CITY OF ALBUQUERQUE

August 4, 2021

**Re: Expect A Miracle
Project Address
Traffic Circulation Layout
Architect's Stamp 07-07-2021 (L18-D081)**

1 **TCL Plan**  
1" = 20'-0"

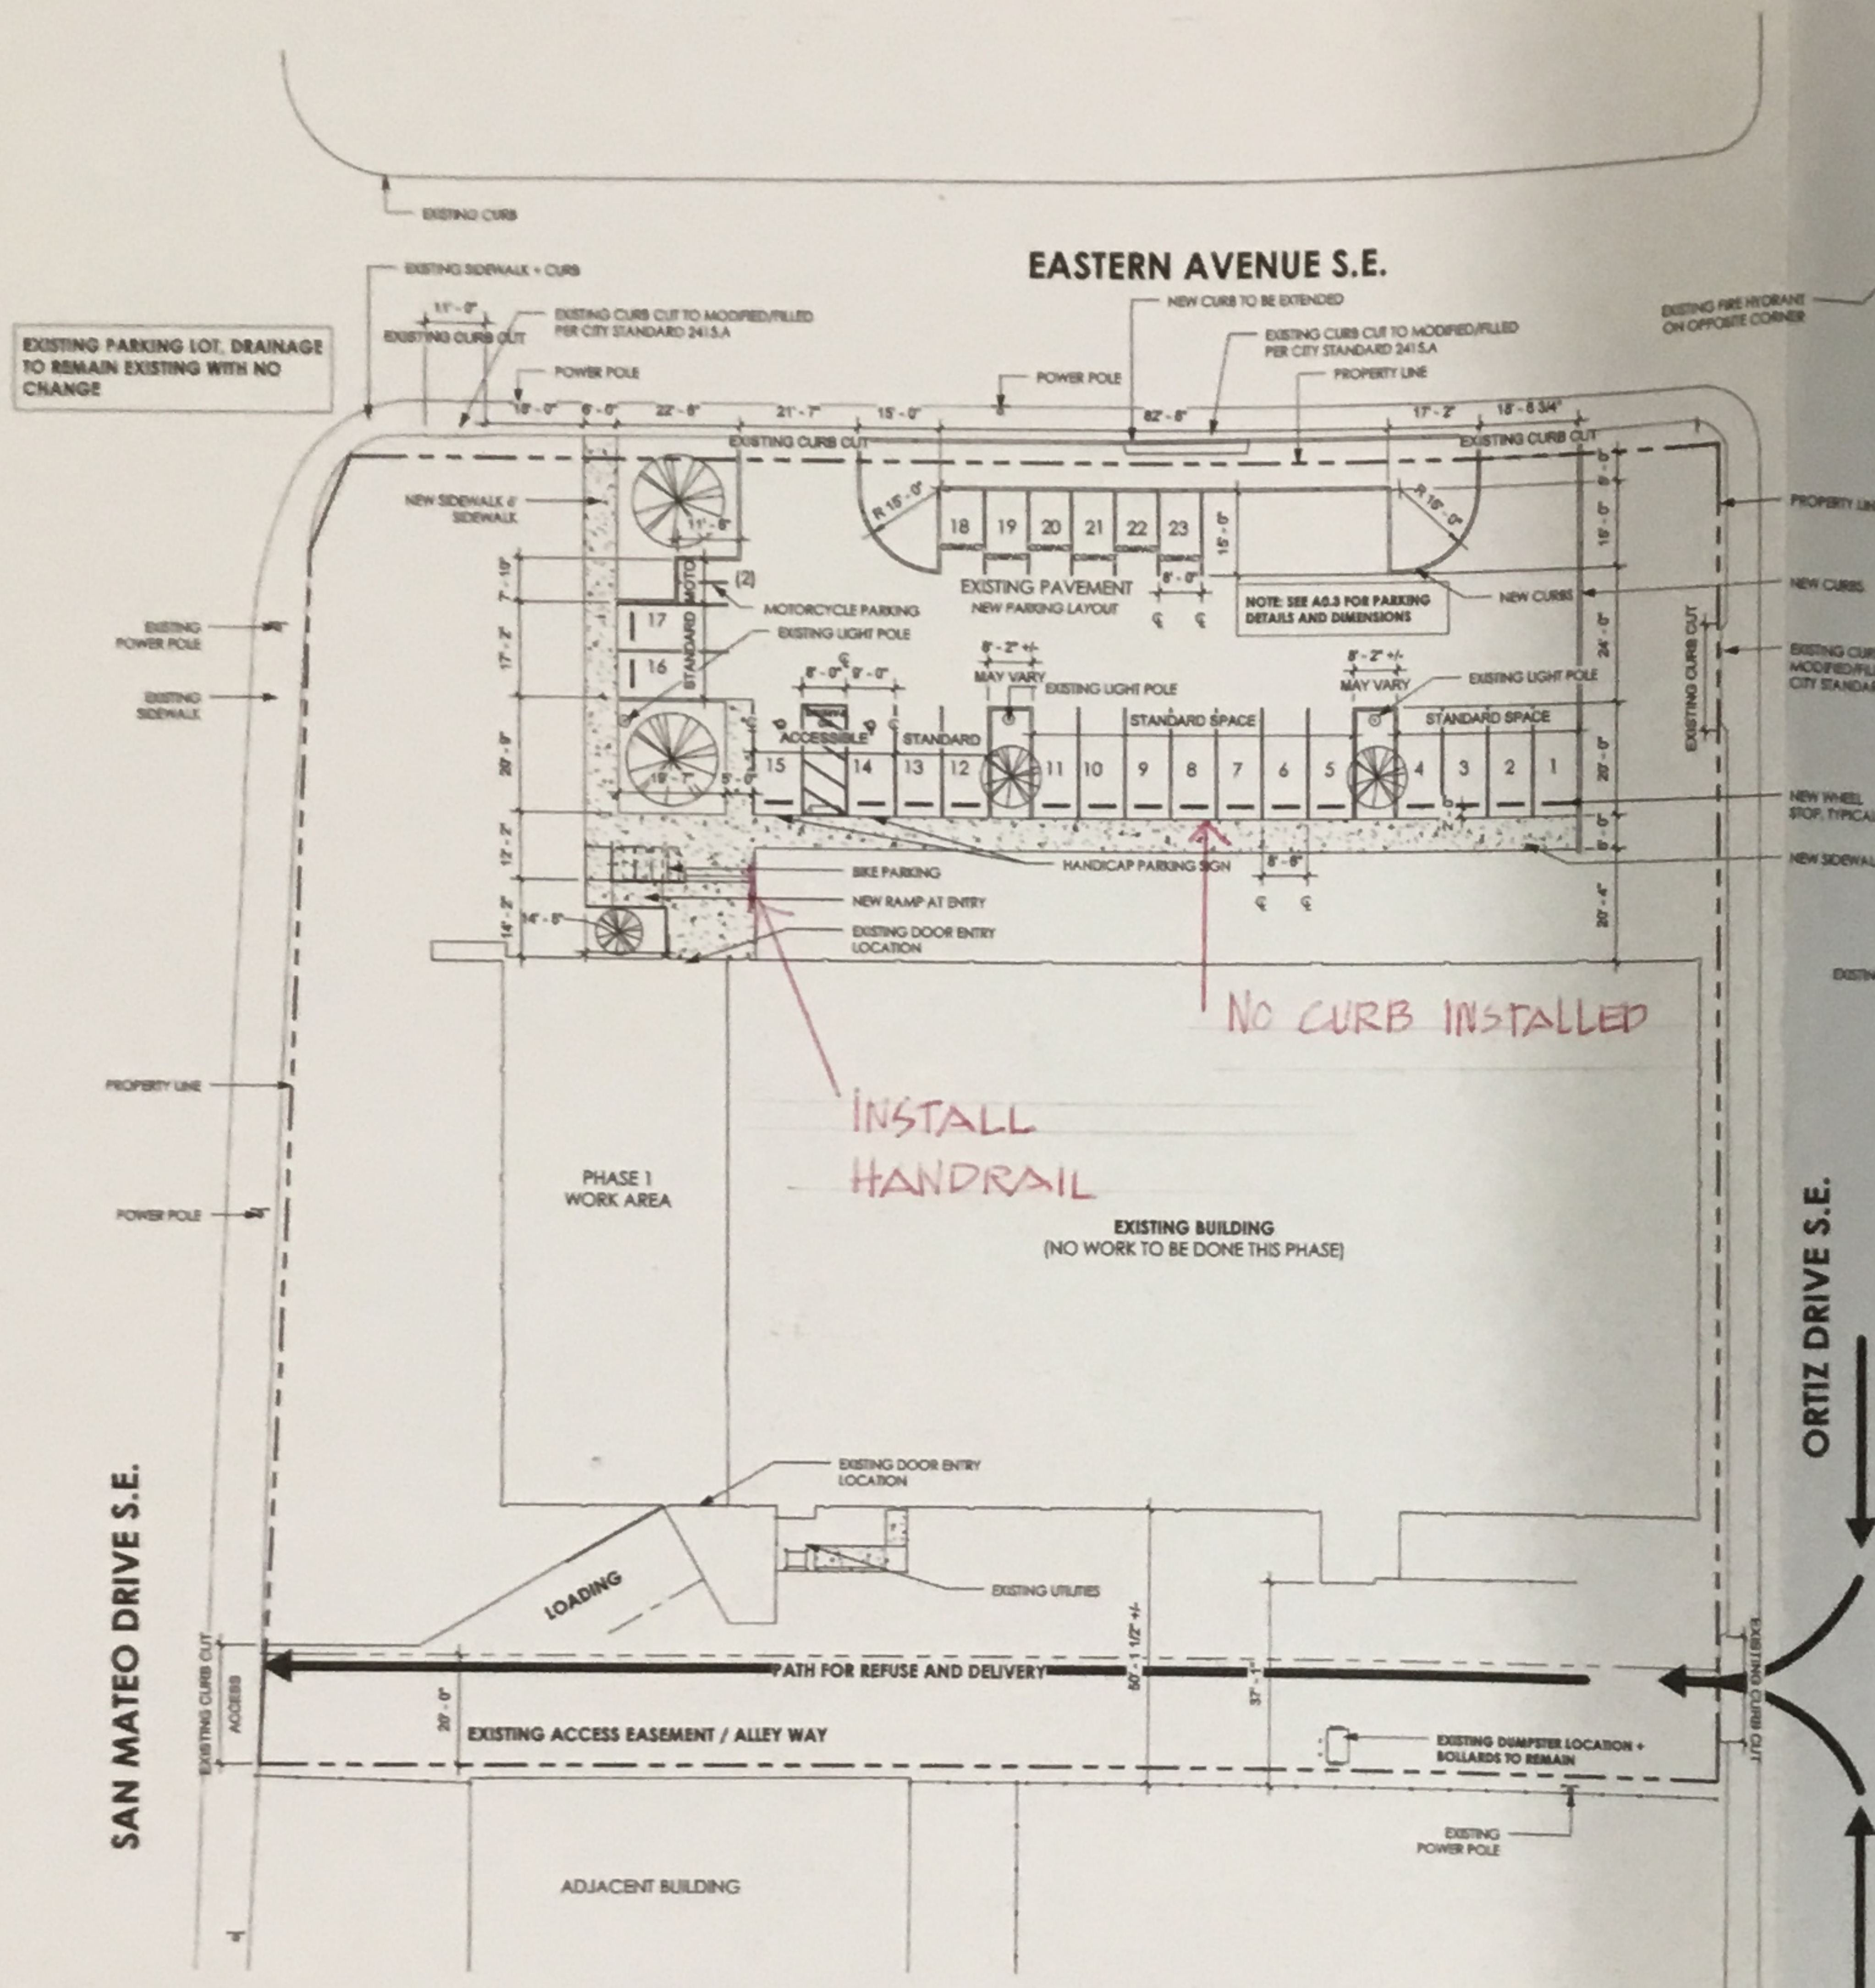
1. Please show a vicinity map showing the location of the development in relation to streets and well known landmarks.
2. Listed are the number of parking spaces required by the IDO as well as the proposed number of parking spaces including bicycle and motorcycle parking. Please coordinate/discuss with Zoning these proposed calculations.
3. **Existing driveways will need to be replaced since they are not ADA compliant. See below:**
 - San Mateo (one driveway).
 - Eastern Ave (both existing driveways).
 - Ortiz Drive (one driveway).
4. **Handrail (proposed) on site:** A detail will need to be provided to assure ADA compliance.
5. Please list the width and length for all existing and proposed parking spaces. Some dimensions are not shown (**Motorcycle**).
6. **The minimum parking stall dimensions are:**

7. The ADA accessible parking sign must have the required language per 66-7-352.4C NMSA 1978 "**Violators Are Subject to a Fine and/or Towing.**" Please call out detail and location of signs.

8. The ADA access aisles shall have the words **"NO PARKING"** in capital letters, each of which shall be at least one foot high and at least two inches wide, placed at the rear of the parking space so as to be close to where an adjacent vehicle's rear tire would be placed. (66-1-4.1.B NMSA 1978) **.Provide the proposed verbiage pavement markings details.**

9. ADA curb ramps must be updated to current standards and have truncated domes installed at the **corner of San Mateo/Eastern Ave.**
10. **Motorcycle parking spaces shall be designated by its own conspicuously posted upright sign, either free-standing or wall mounted per the zoning code.Label pavement MC.**

11. **All bicycle racks shall be designed according to the following guidelines:**
 - a. The rack shall be a minimum 30 inches tall and 18 inches wide.
 - b. The bicycle frame shall be supported horizontally at two or more places. Comb/toaster racks are not allowed.

12. Bicycle racks shall be sturdy and anchored to a concrete pad.
13. A 1-foot clear zone around the bicycle parking stall shall be provided.
14. Bicycle parking spaces shall be at least 6 feet long and 2 feet wide.

15. List radii for all curves shown; for passenger vehicles. Radius for delivery trucks, **fire trucks, etc. is 25 ft. or larger. Please coordinate with FD for proposed layout plan.**

16. **A 5 ft. keyway is required for dead-end parking aisles.**
17. Per DPM, a **6 ft. wide ADA accessible pedestrian pathway is required from the ADA parking stall access aisles to the building entrances.** Please clearly show this pathway and provide details.

18. Provide a copy of refuse approval.
19. Please provide a sight distance exhibit
20. Show the clear sight triangle and add the following note to the plan: **"Landscaping and signage will not interfere with clear sight requirements. Therefore, signs, walls, trees, and shrubbery between 3 and 8 feet tall (as measured from the gutter pan) will not be acceptable in the clear sight triangle.**

22. **San Mateo frontage/sidewalk:** There are tree planters are damaged and appear to be a tripping hazard to the public. This safety concern will need to be addressed.
